From: Andrew Fuller [REDACTED]
Sent: 05 March 2018 12:31
To: Anita Gardner
Cc: Juan Baeza; Martyn White; Nick Field; mv rowan; AFA
Subject: Re: Planning Consultation on: AB/149/17/L

**Listed Building Consent for Alterations, Extension or Demolition of a Listed Building
APPLICATION AB/149/17/L**

Site Address: 44 Tarrant Street Arundel BN18 9DN

Description of Works: Listed building consent for internal alterations & renovations

Drawing No
171164/ 103
Status
Revision
A

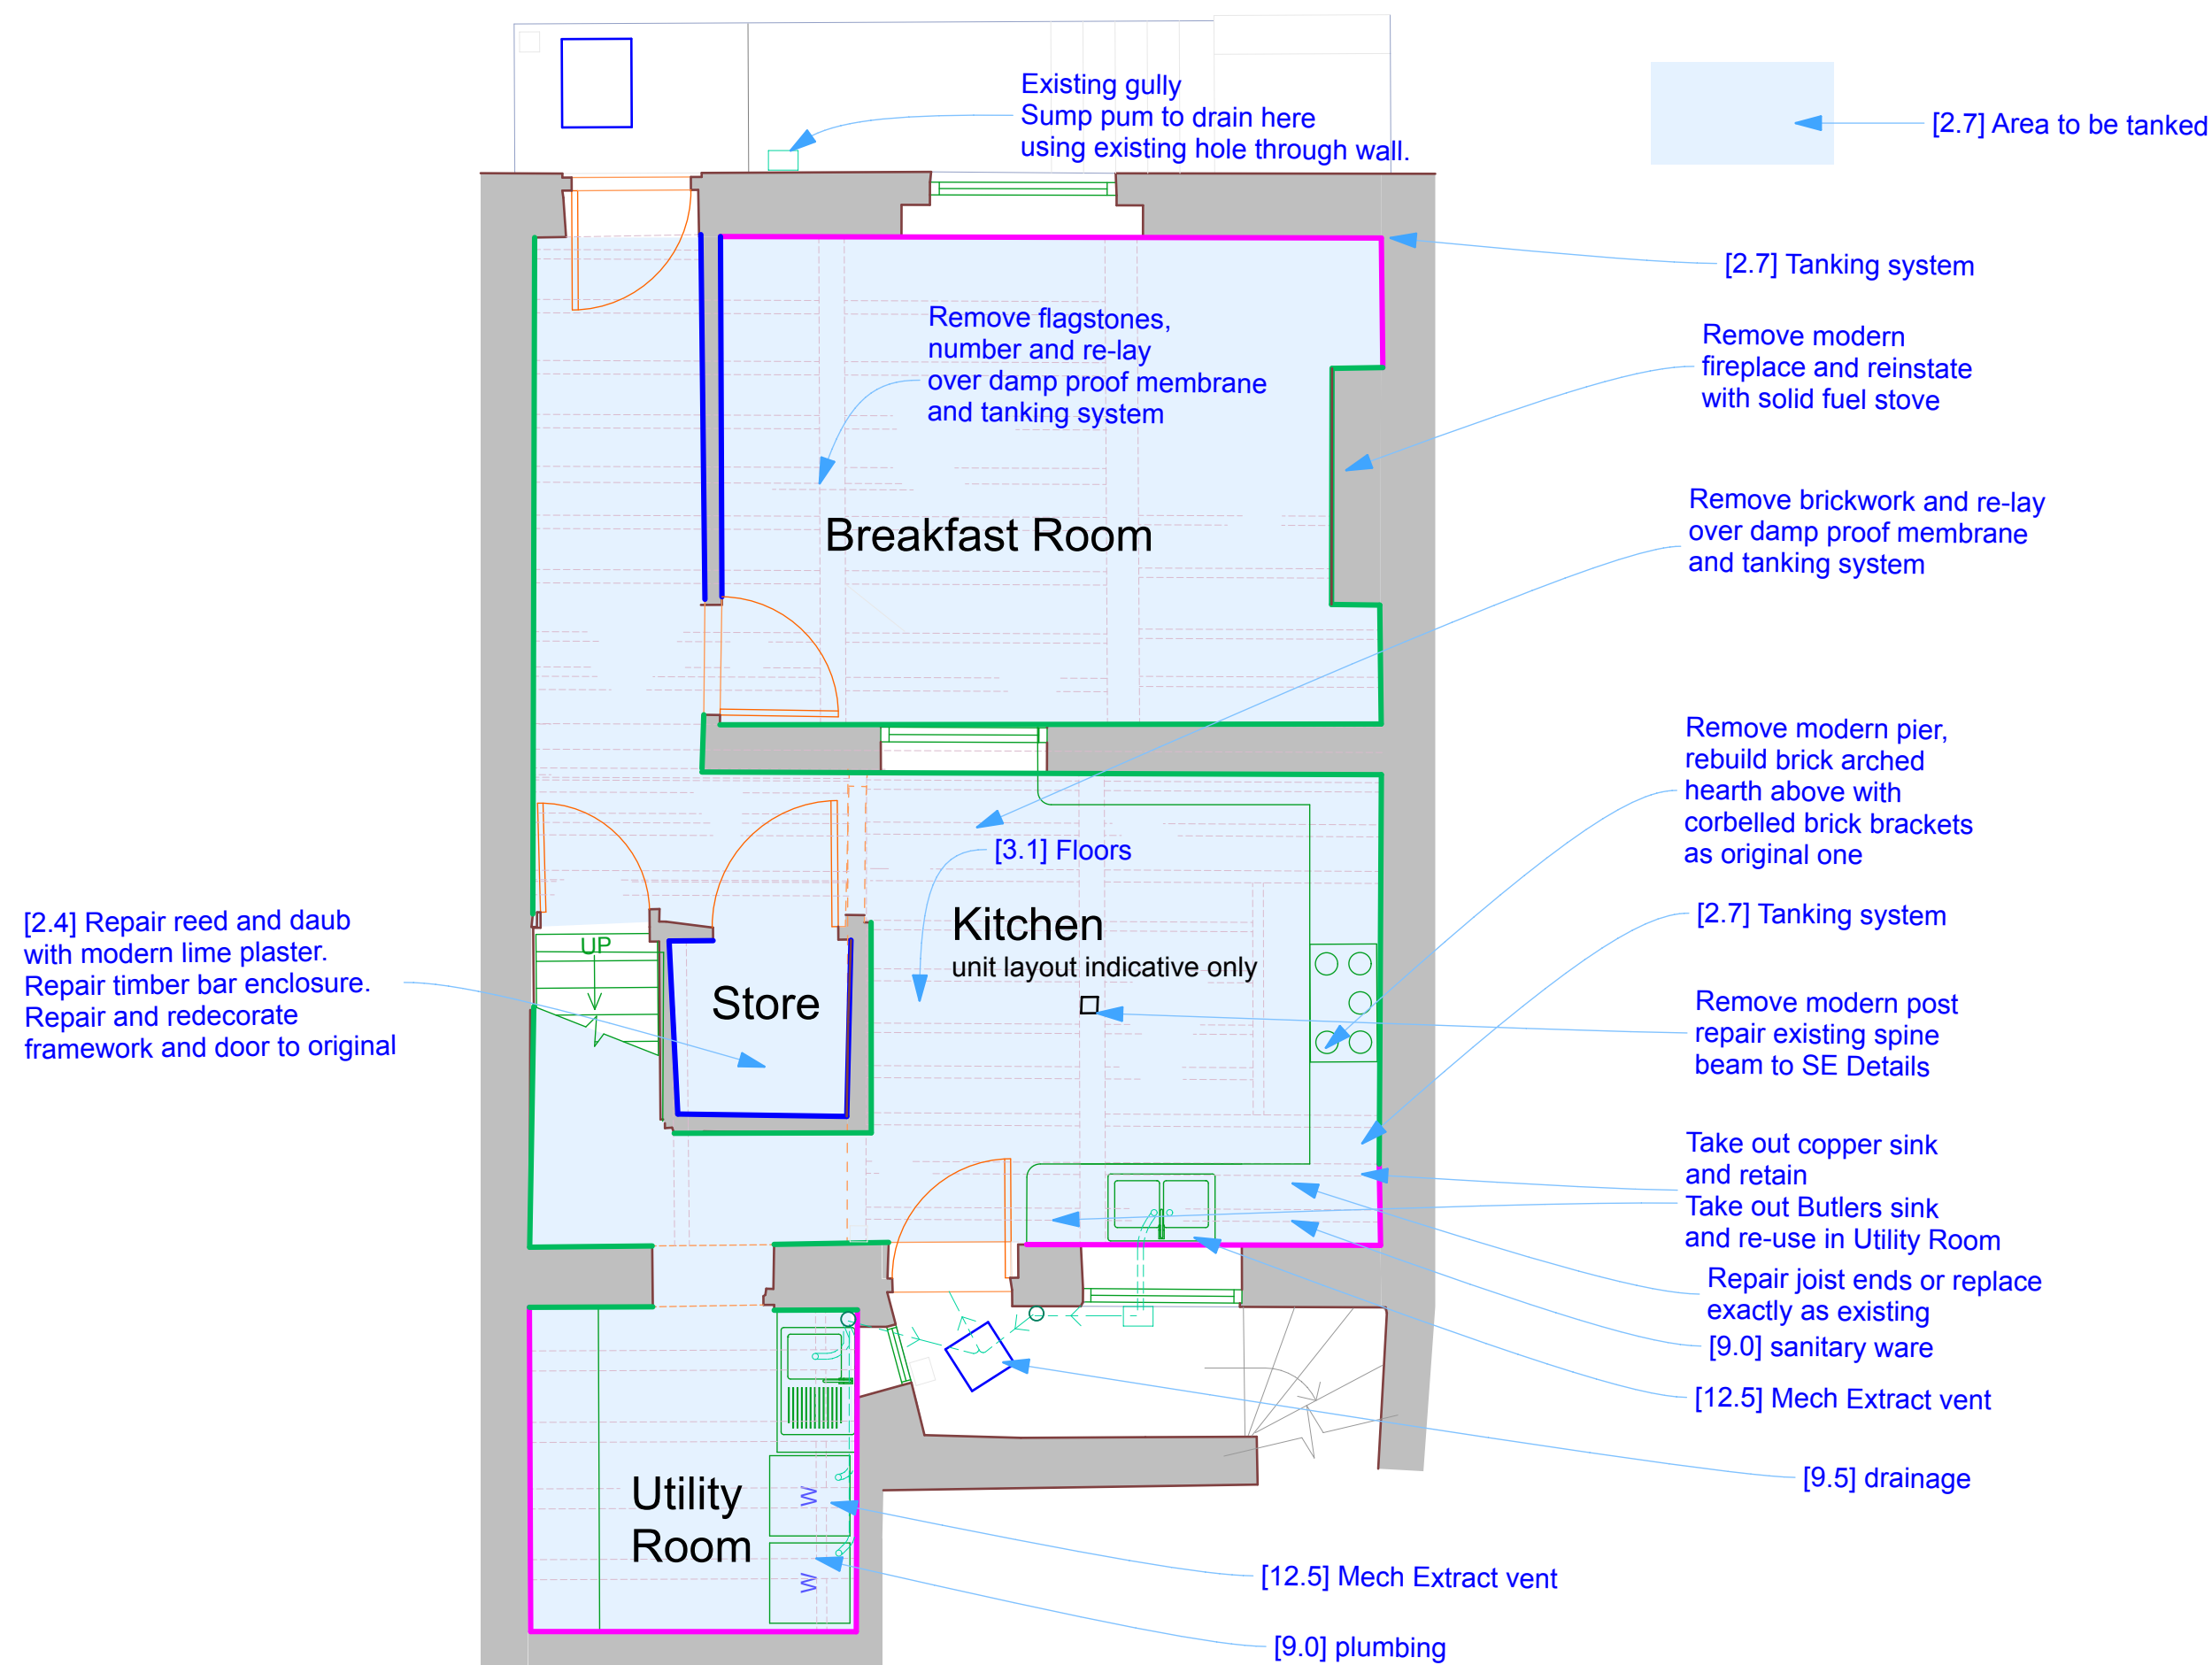
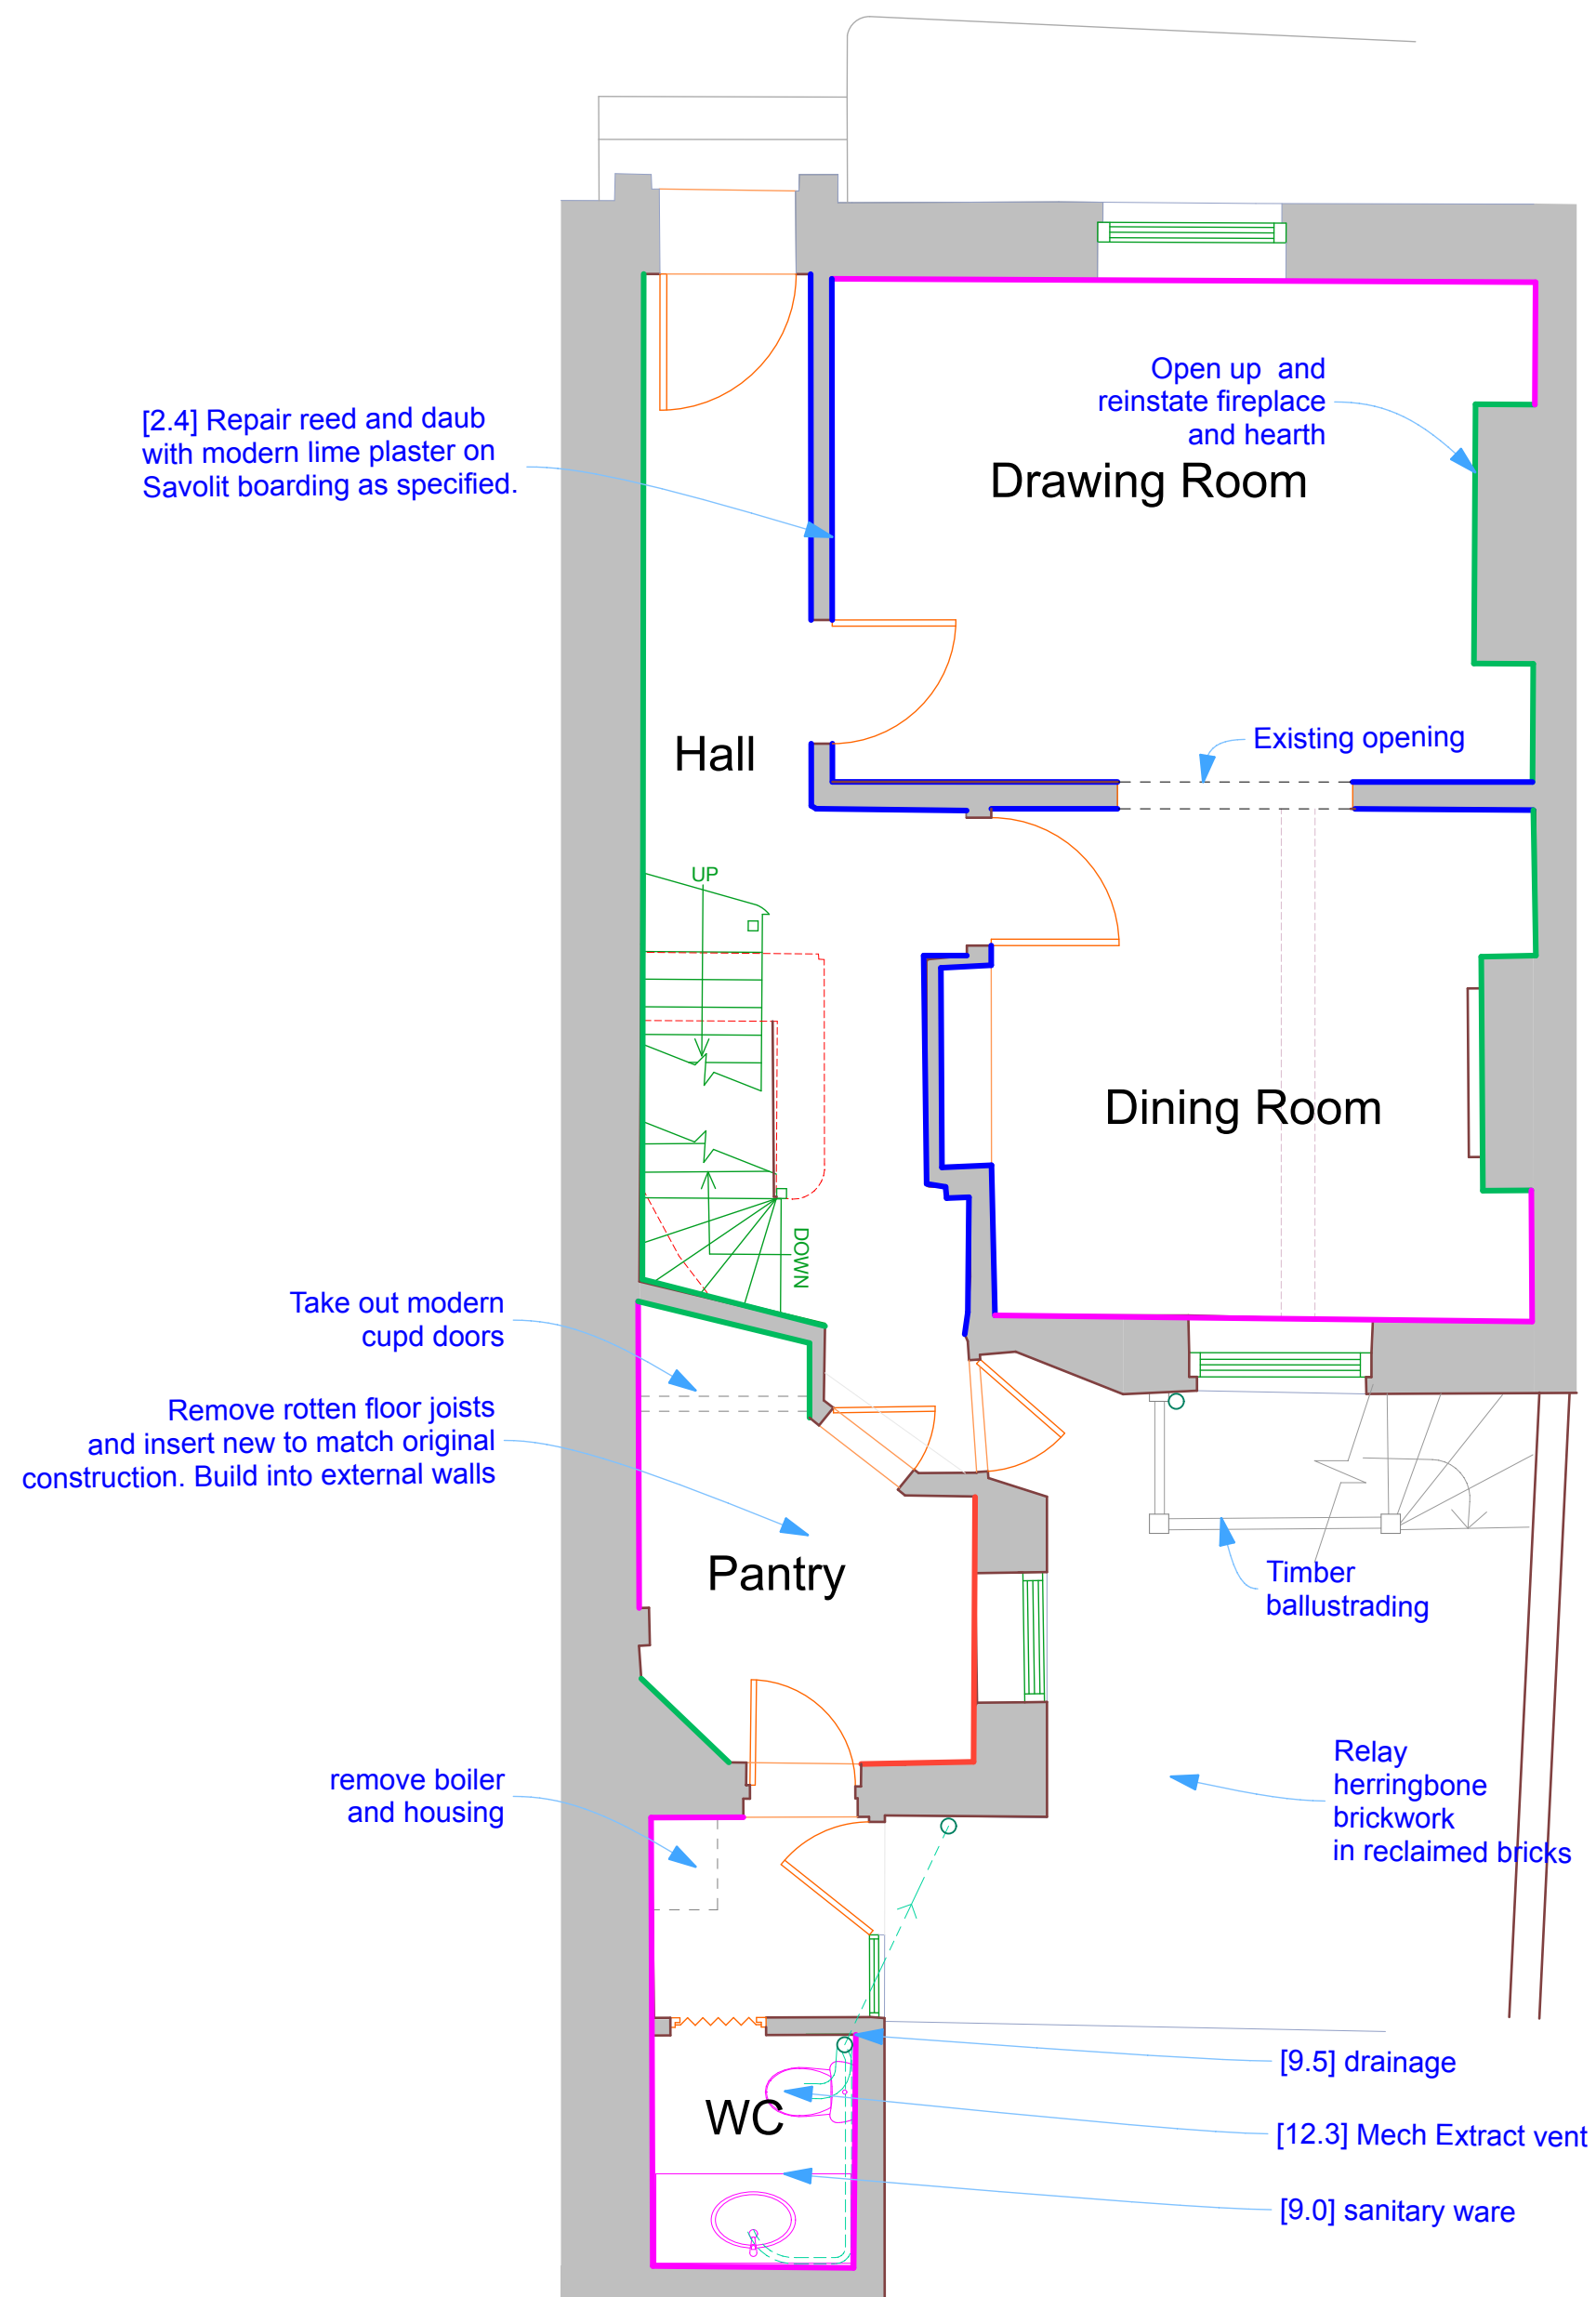
- Existing floor plan. The submitted plans marked 'Planning & Building Regulations', show some dotted lines which I presume to be walls which have been removed. For clarity, a set of plans which show the building before any works had been carried out should be submitted. Such should include features that would appear on plan.

- Submitted Drawings: Works refer to internal works only, while external works appear to have been carried out. It is noted that some reference to 'relay herringbone paving and timber balustrading' is noted on Dwg 17/164/103 Works would appear to exceed this description. Description supplied in 'Description of Works' is incomplete.

The floor plans show clearly the minor removal of modern stud work walling, mostly cupboards. This can be confirmed to be consistent upon inspection also.

We propose that approval of details of external works, namely replacement of modern paving with herringbone brick paviours and cast iron railings be made a condition.
